# CITY OF ALBUQUERQUE

March 9, 2023

**Re: Mesa Del Sol Trackt A Multi-Family**  
**T.B.D. Northeast corner of North Mesa del Sol Blvd. & West University Blvd.**  
**Traffic Circulation Layout**  
Engineer's/Architect's Stamp XX-XX-XX (R16-D097C)

**TYPICAL MOTORCYCLE PARKING STALL**

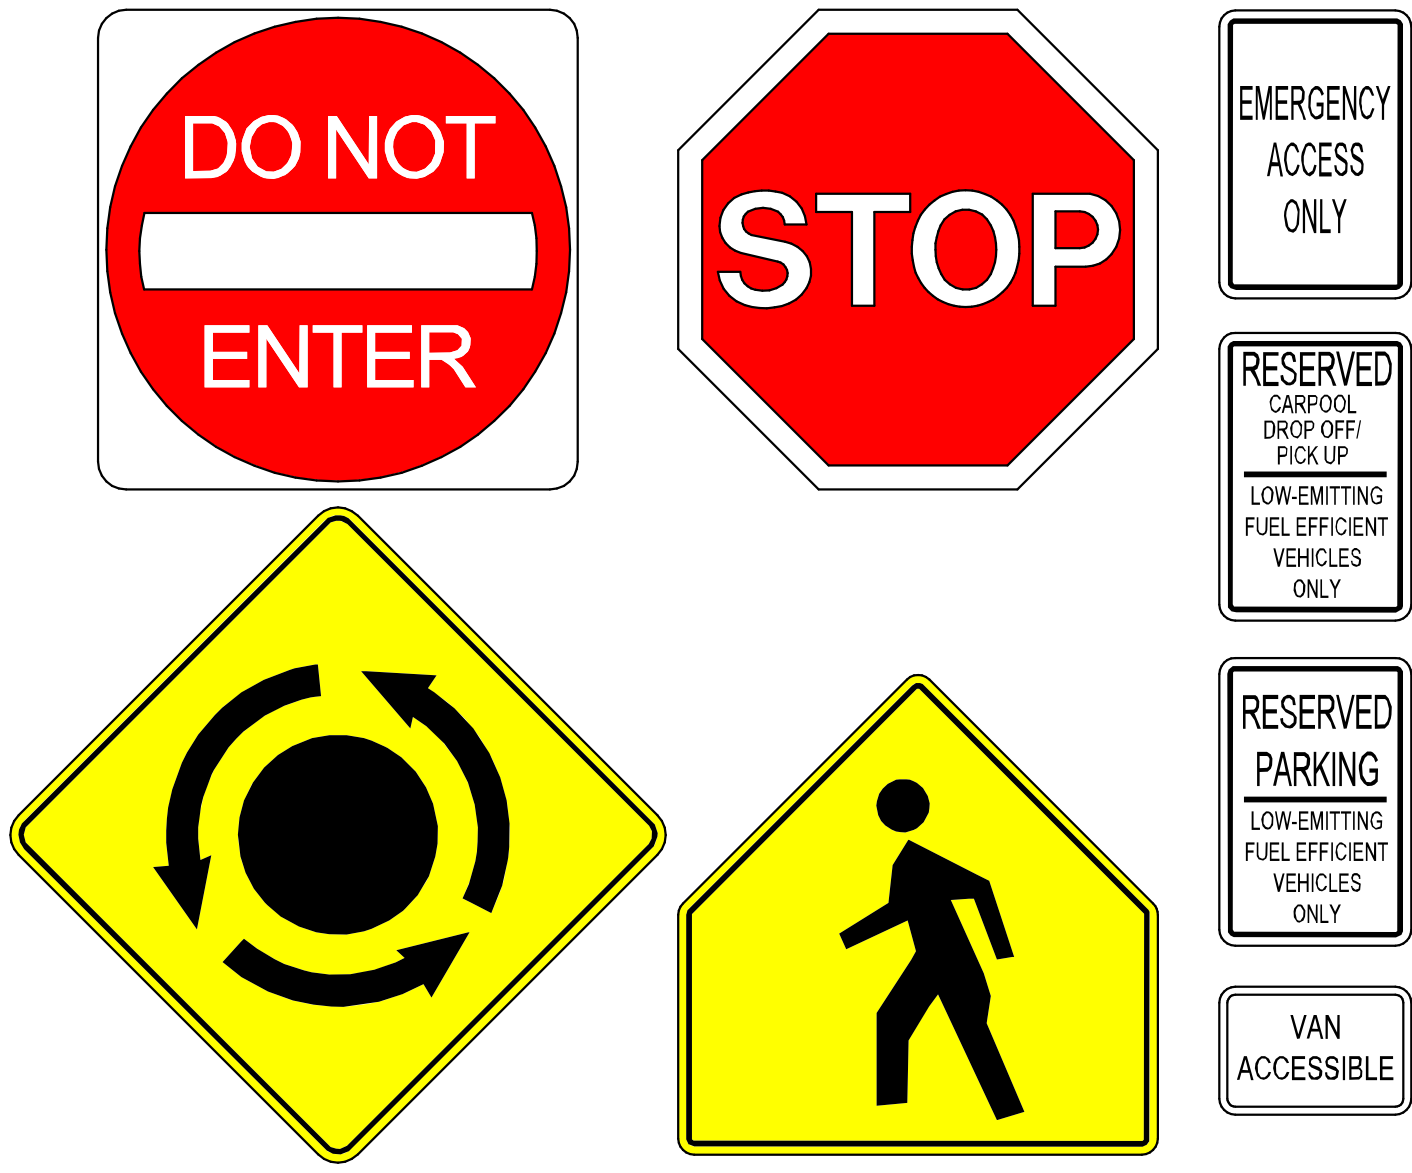
13. Motorcycle parking spaces shall be designated by its own conspicuously posted upright sign, either free-standing or wall mounted per the zoning code.

14. The pavement marking "MC" should be shown in the opposite direction for motorcycles entering the parking space.
15. All bicycle racks shall be designed according to the following guidelines:

**BICYCLE RACK**

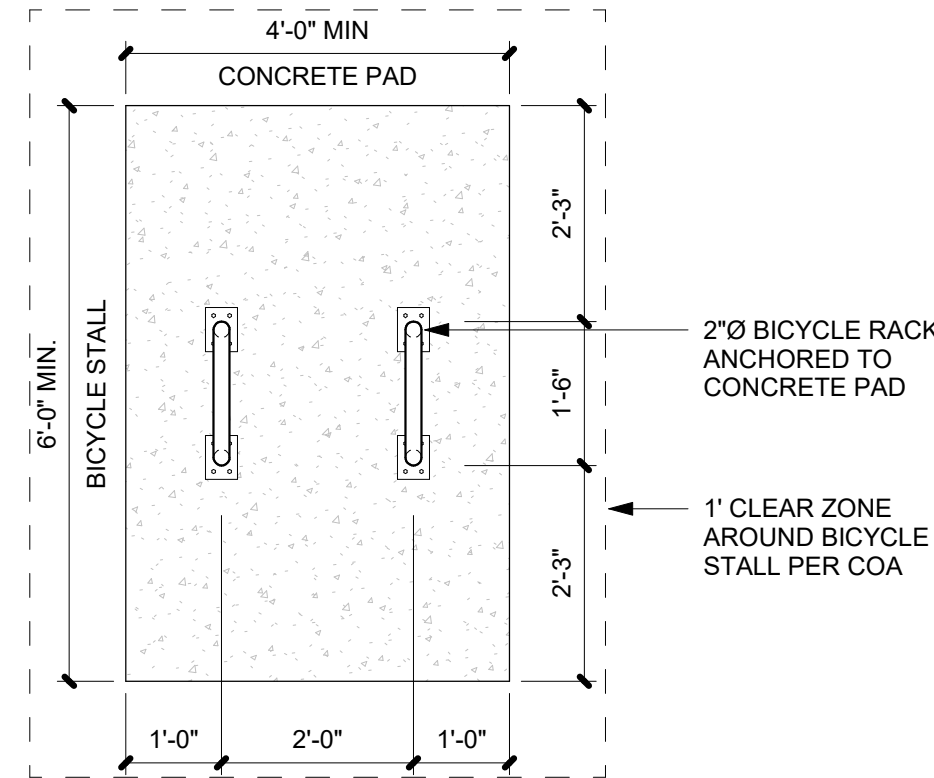
- a. The rack shall be a minimum 30 inches tall and 18 inches wide.
  - b. The bicycle frame shall be supported horizontally at two or more places. Comb/toaster racks are not allowed.

- c. The rack shall be designed to support the bicycle in an upright position. See the IDO for additional information.
  - d. The rack allows varying bicycle frame sizes and styles to be attached.

- e. The user is not required to lift the bicycle onto the bicycle rack.
  - f. Each bicycle parking space is accessible without moving another bicycle.

16. Bicycle racks shall be sturdy and anchored to a concrete pad.
17. A 1-foot clear zone around the bicycle parking stall shall be provided.
18. Bicycle parking spaces shall be at least 6 feet long and 2 feet wide.

A1 OVERALL SITE PLAN  
1" = 50'-0"

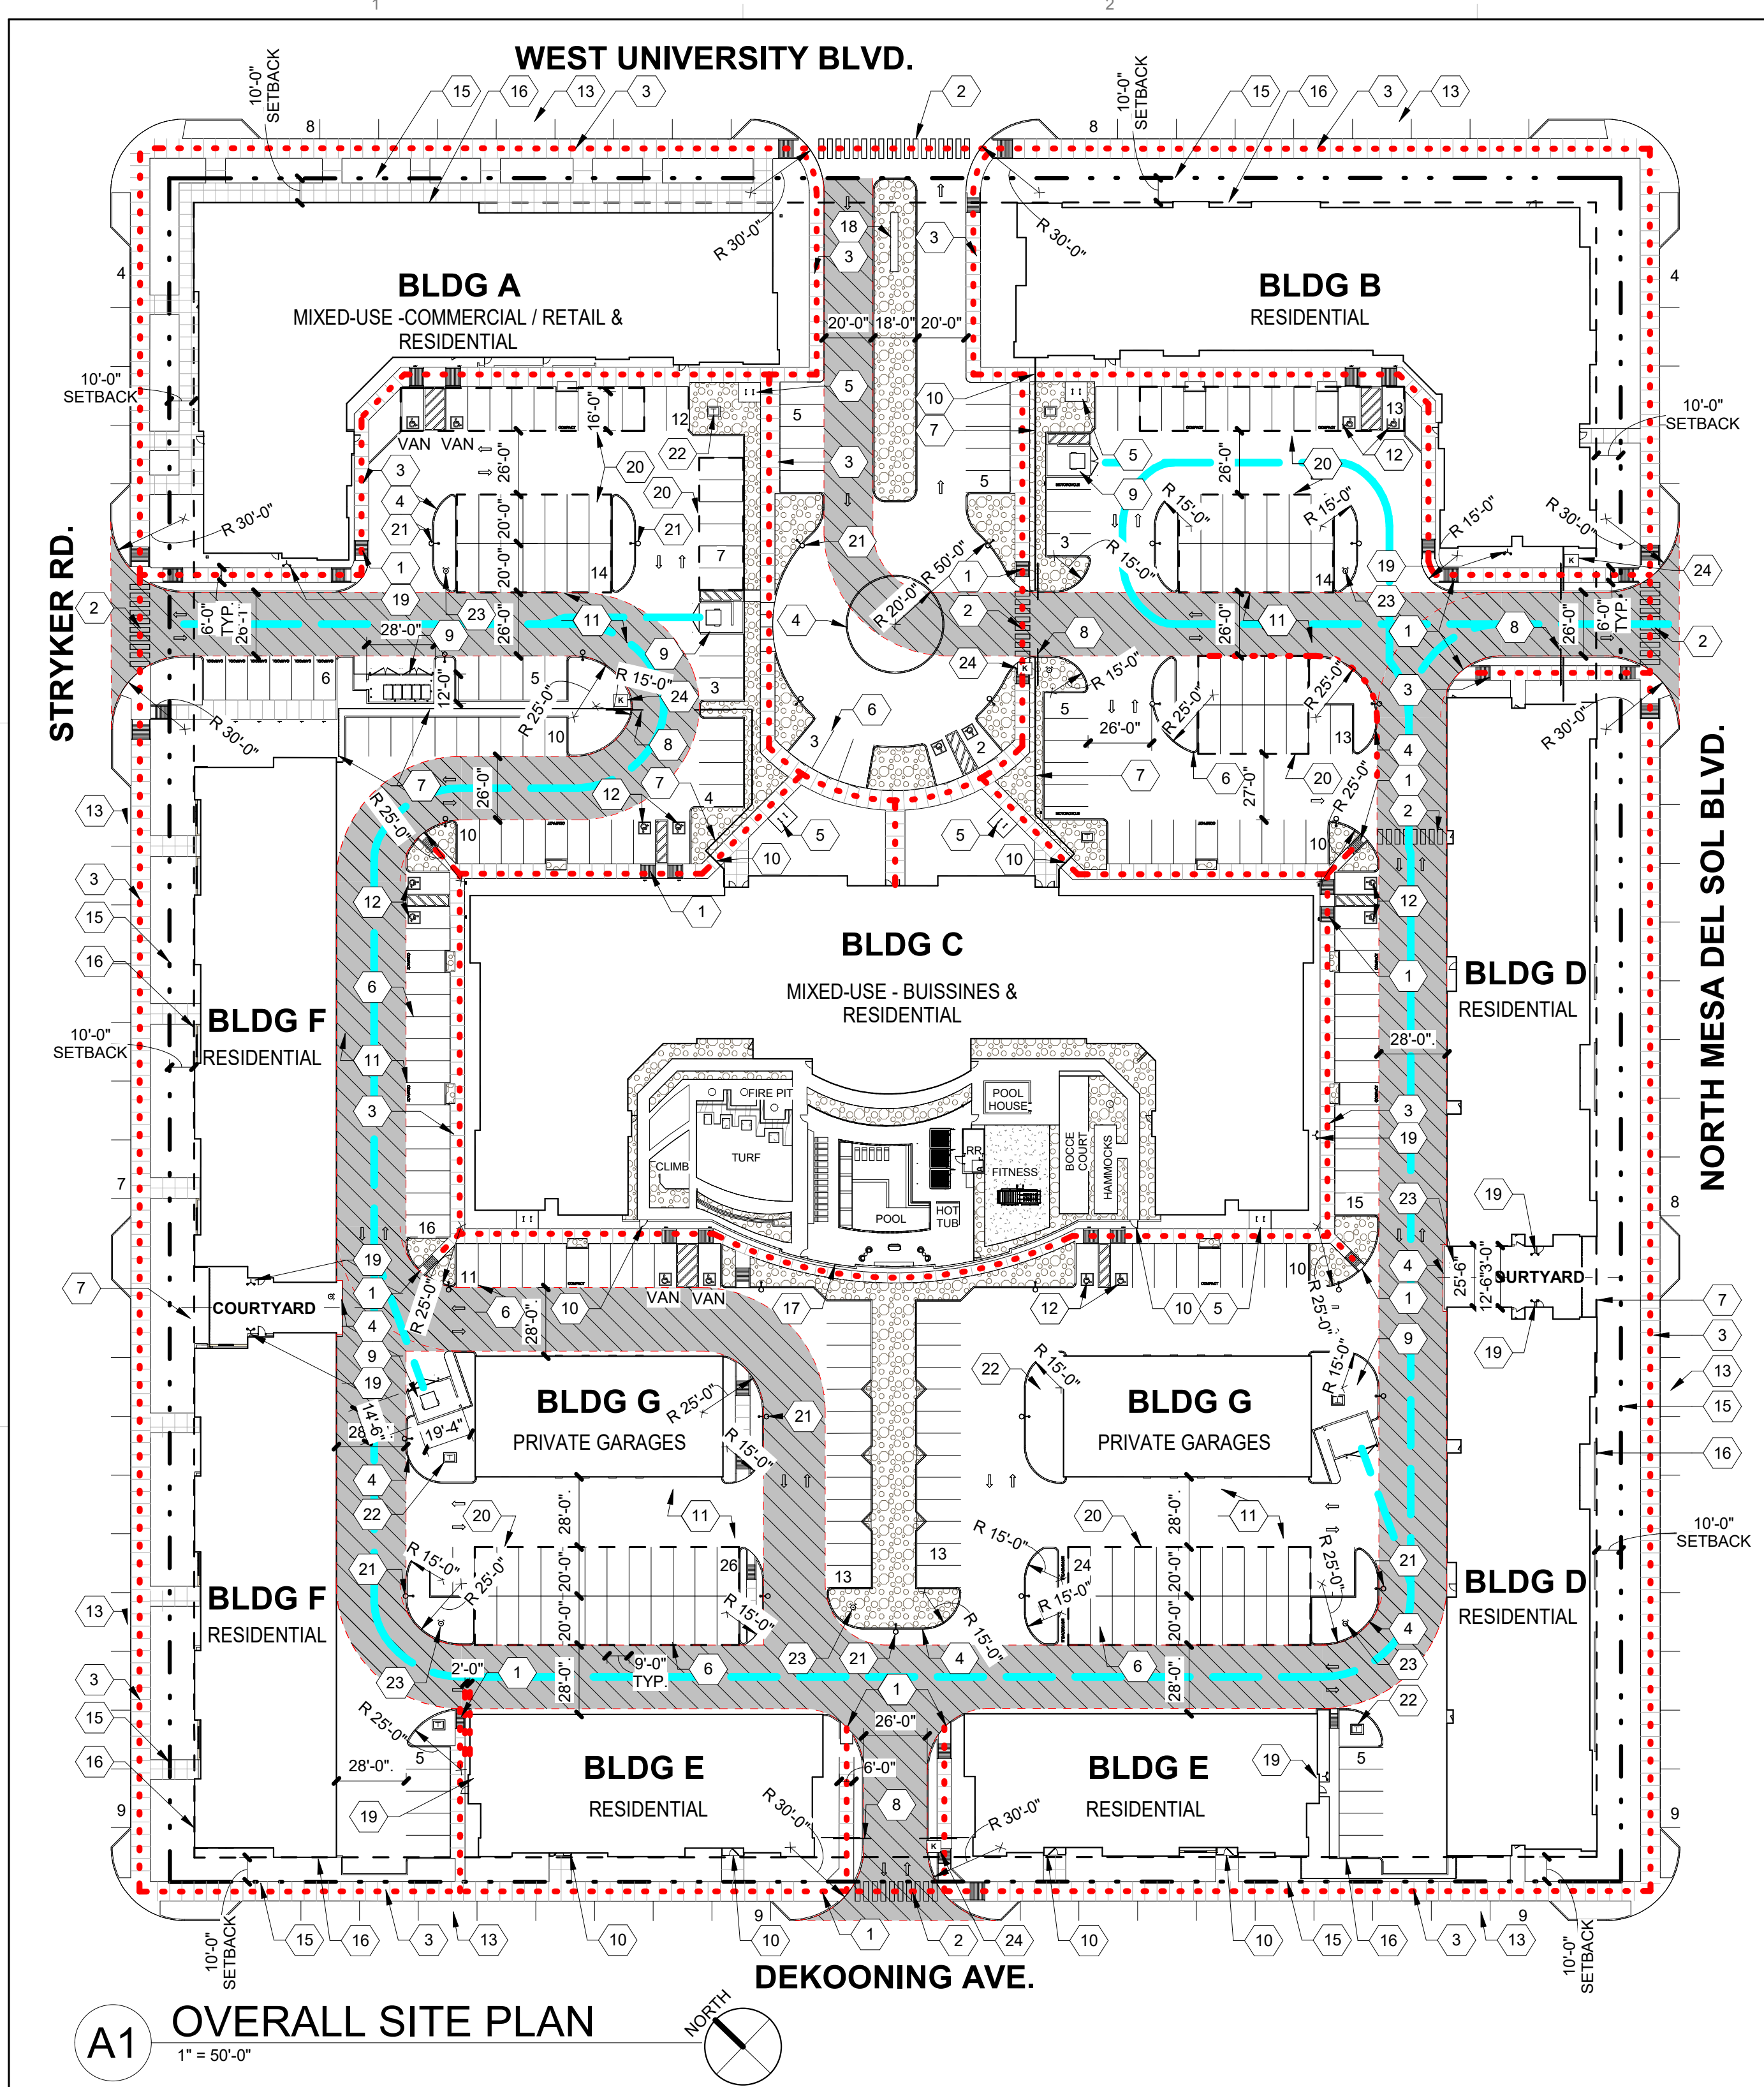
1. List the number of parking spaces required by the IDO as well as the proposed number of parking spaces including bicycle and motorcycle parking.
2. The traffic circulation layout must be stamped, signed, and dated by an engineer or architect licensed in the state of New Mexico.

3. Identify all existing access easements and rights of way width dimensions.
4. Identify the right of way width, medians, curb cuts, and street widths on West University Blvd., North Mesa Del Sol Blvd., Dekooning Ave., and Stryker Rd.

7. Provide dimensions for all the proposed On-Street parking spaces.
8. Please show on the site plan 20' long space between the crosswalk or pedestrian crossing and the nearest On-street parking space.

TYPICAL ACCESSIBLE PARKING  
1/8" = 1'-0"

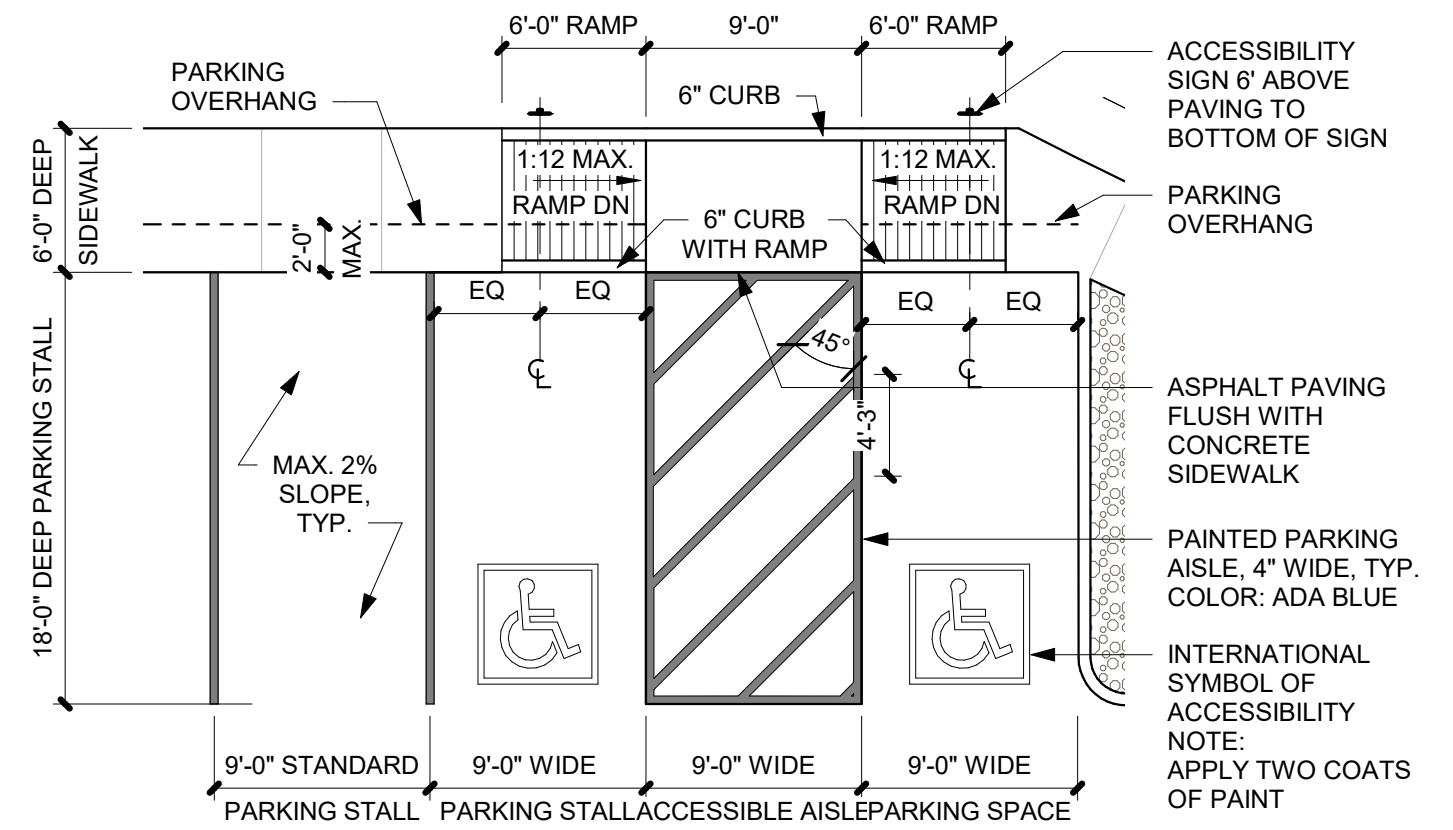
11. The ADA accessible parking sign must have the required language per 66-7-352.4C NMSA 1978 **"Violators Are Subject to a Fine and/or Towing."** Please call out detail and location of signs.

12. The ADA access aisles shall have the words **"NO PARKING"** in capital letters, each of which shall be at least one foot high and at least two inches wide, placed at the rear of the parking space so as to be close to where an adjacent vehicle's rear tire would be placed. (66-1-4.1. B NMSA 1978)
